**DPIE Submissions Response**

State Significant Development SSD-17424905  
Pymble Ladies College – Grey House Precinct  
20 Avon Road, Pymble (Lot 1 DP 69541)

**Table 1 RESPONSE TO INFORMATION REQUEST**

57A & 59B Pymble Ave Shadow Diagrams for 21 June 9 - 11 am

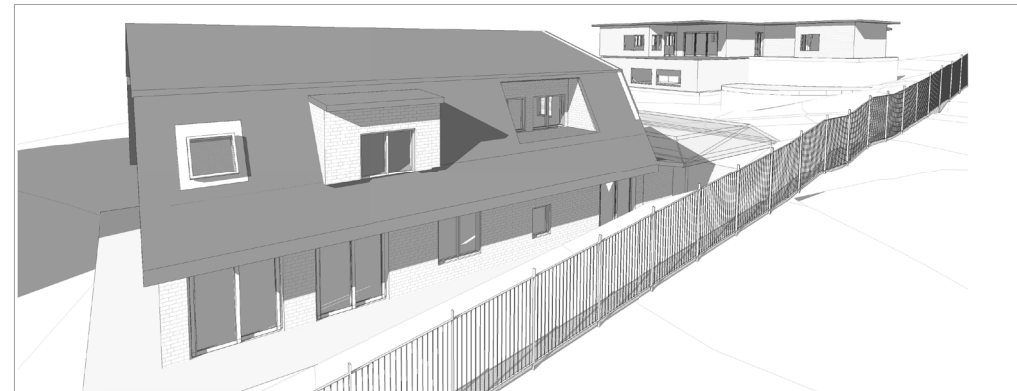
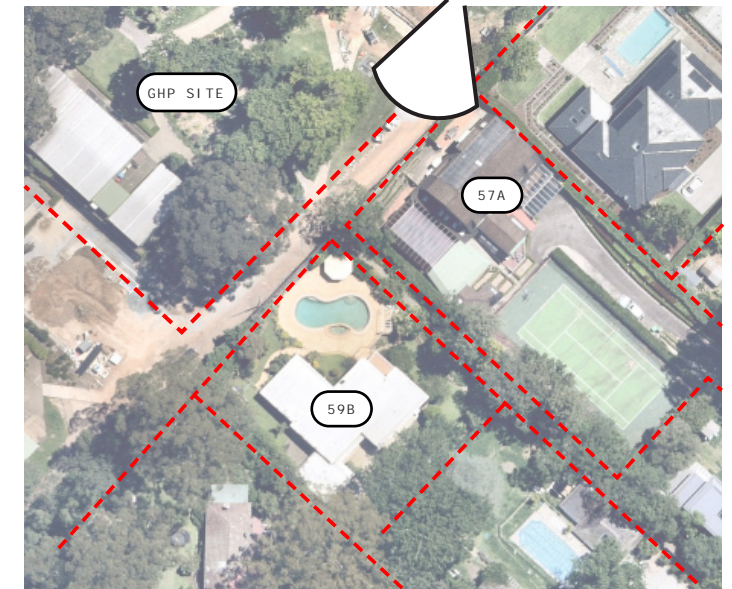
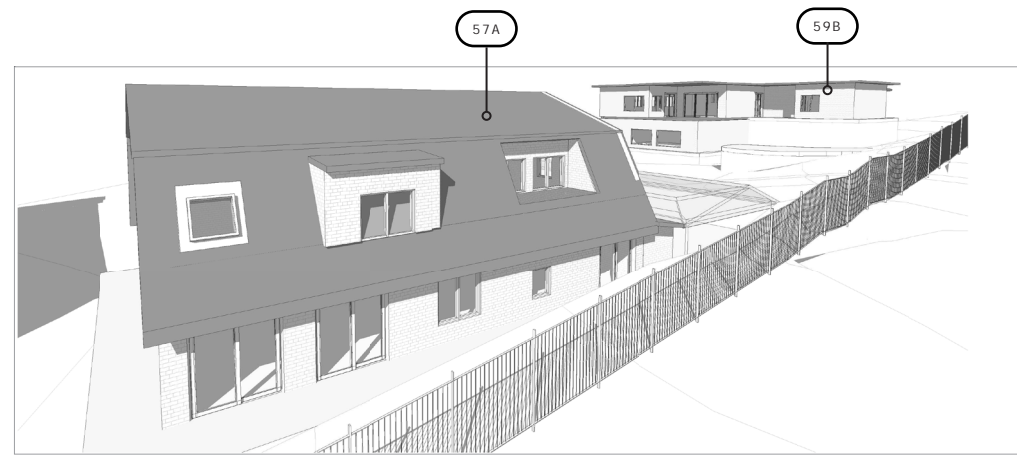
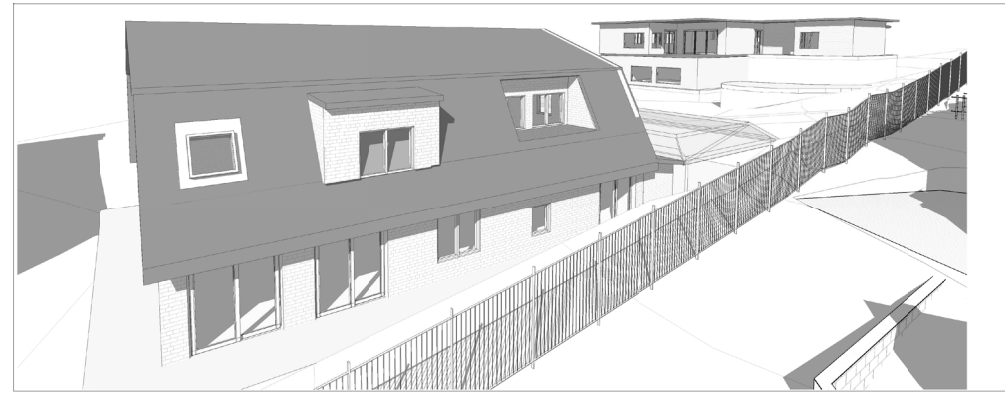
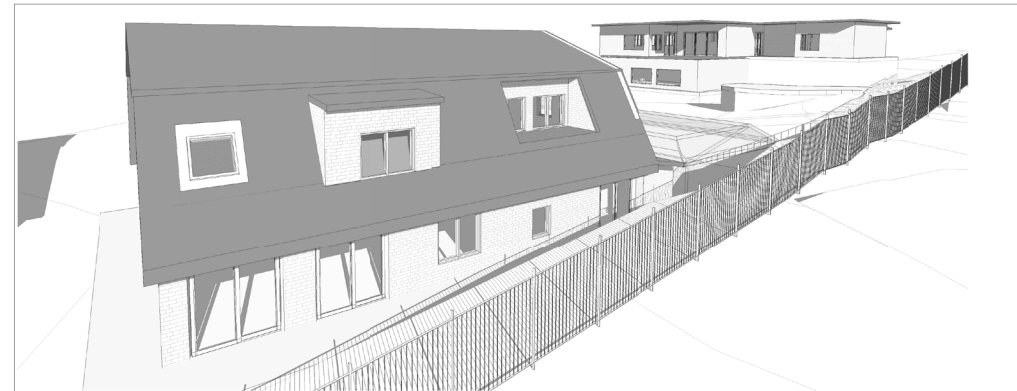
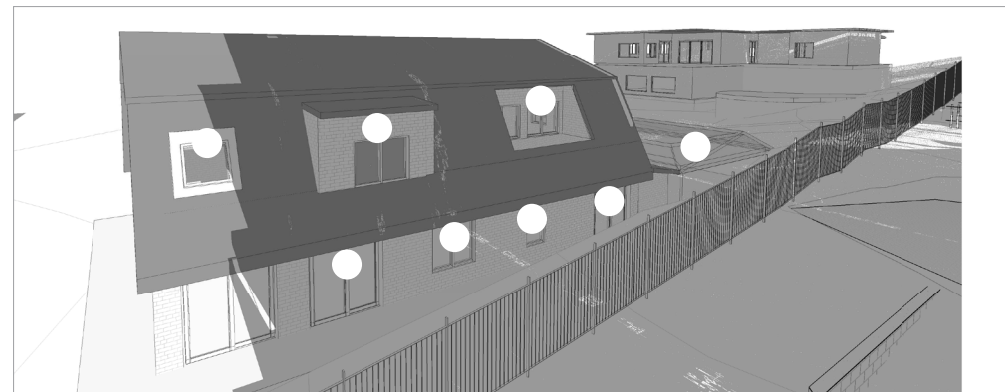
Table 1 RESPONSE TO INFORMATION REQUEST	
	be no privacy impacts from the proposed development to neighbouring residential properties.
According to the Ku-ring-gai Development Control Plan, a building should be sited to maintain solar access to north facing windows and rear yards of adjoining properties of at least four hours between 9am and 3pm on 21st June. The proposed development does not comply with this requirement. Please address this issue and demonstrate how the development would maintain an appropriate level of solar access to the impacted properties (to its south) during winter solstice.	<p>It is noted that under Clause 11 of the <i>State Environmental Planning Policy (State and Regional Development) 2011</i> (SRD SEPP) Development Control Plans (DCP) do not apply to State significant development. Notwithstanding this an assessment has been made against the requirements of the Ku-ring-gai DCP 2021 (KDCP 2021) (<b>Attachment J</b>).</p> <p>Solar access is an important consideration for neighbouring amenity and has been considered in the design. Some additional design changes, including stepping the building back to the south-eastern elevation has further improved solar access to the neighbouring properties. As shown in the Design Report Addendum (<b>Attachment B</b>), shadowing to the gardens of properties at 57A and 59B starts after 12pm on 21 June. Shadows fall onto the building at 57A at around 1pm, and to 59B at around 2pm. It is considered that these properties receive at least 3 hours of daylight from 9am on the 21<sup>st</sup> June, in line with State guidance from the Apartment Design Guide and mixed use development stipulated under the KDCP 2021. The key living areas and front/side garden spaces of the two neighbouring residential properties are also able to still gain up to 4 hours of solar access. Overall, it is considered that these properties will still receive adequate solar access and clearer solar diagrams have been prepared to demonstrate this compliance (Attachment B).</p>

DEVELOPMENT OF FACADE - SHADING

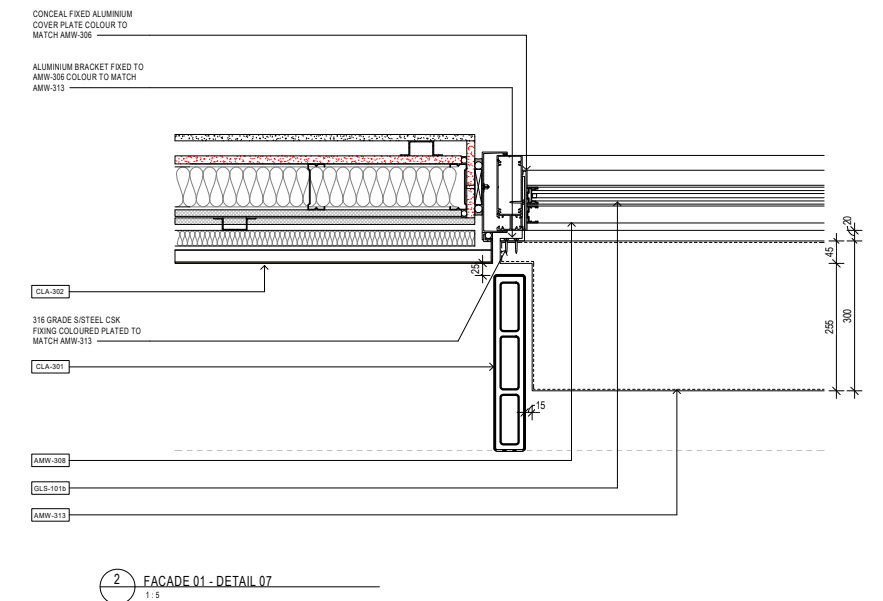
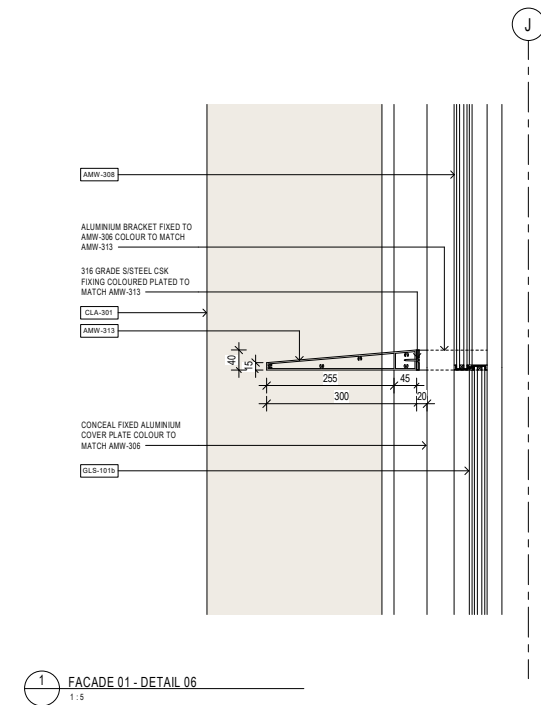
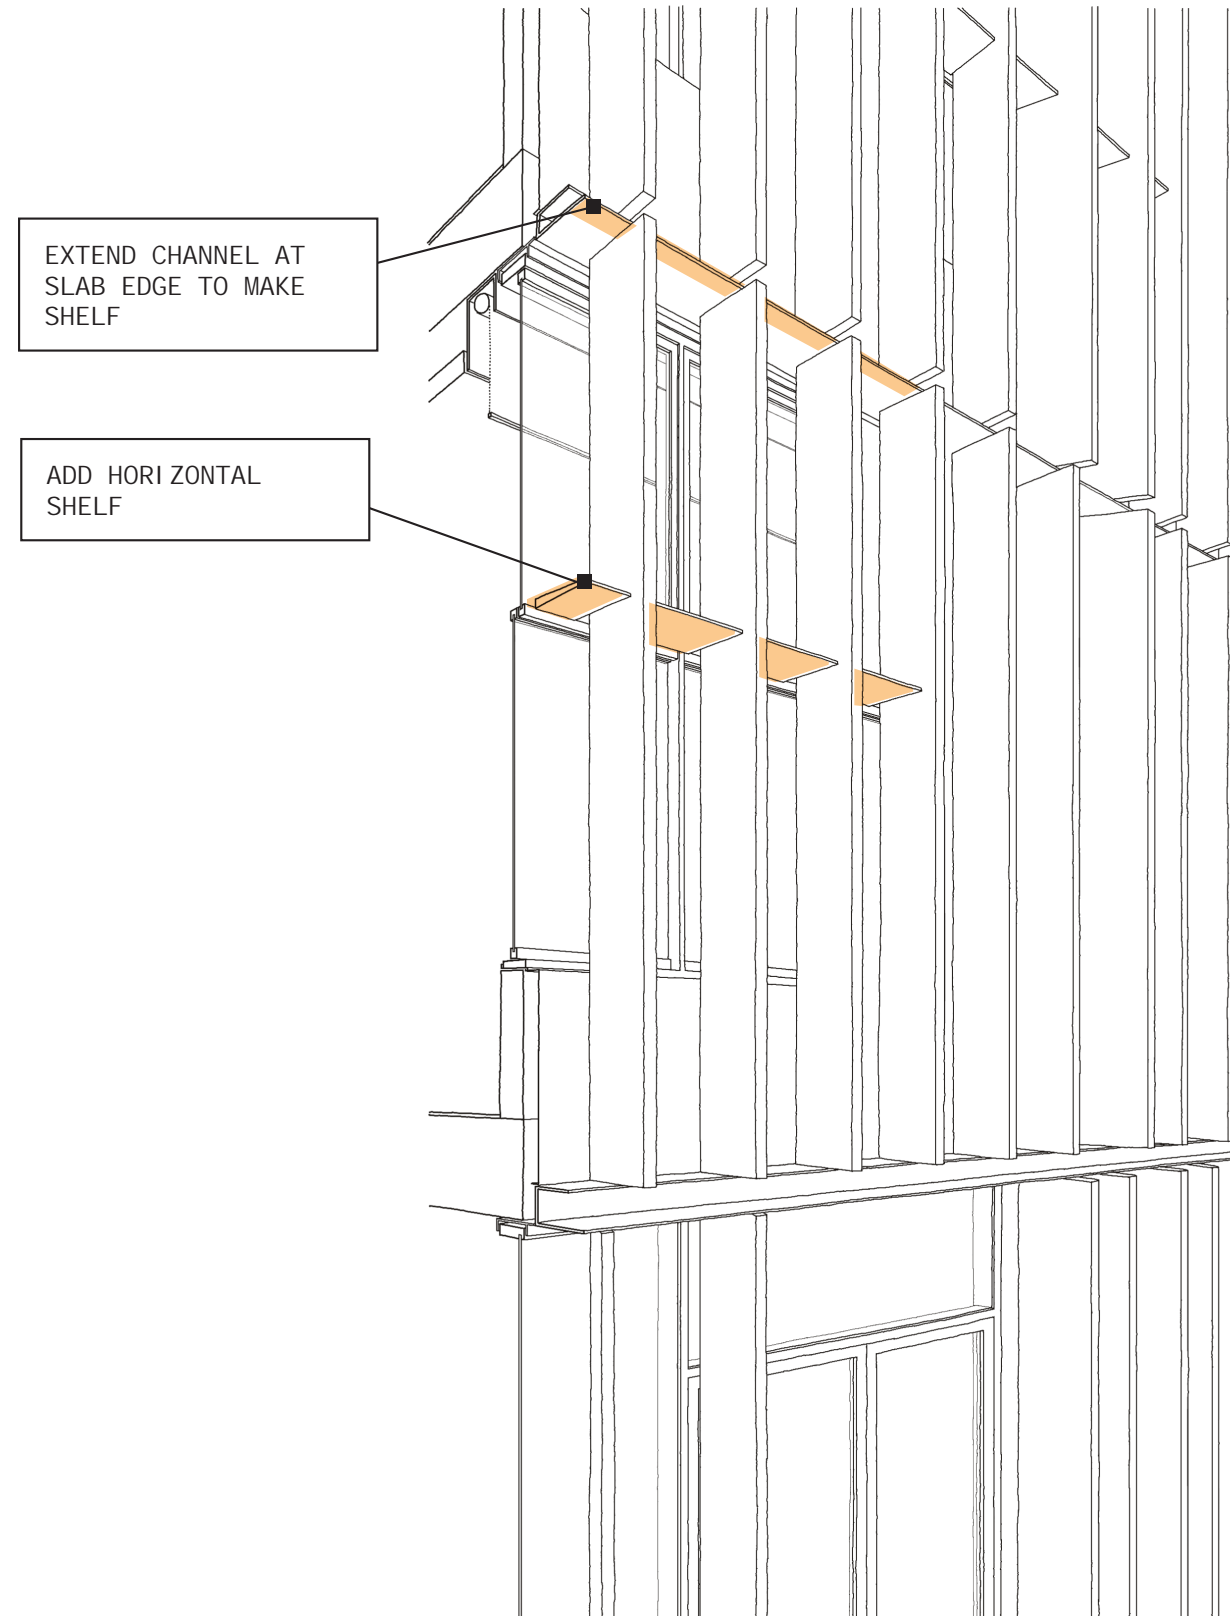
The proposed glazing treatment should be complimented with more horizontal shading strategies to improve daylight and enable access to natural ventilation.	Additional horizontal shading has been provided through the extension of the window hoods, which improves solar protection while still allowing ample natural daylight within the teaching spaces. A horizontal shelf/awning is also incorporated into the façade breaking up the verticality of the building at the mid point ( <b>Attachment A and B</b> ).
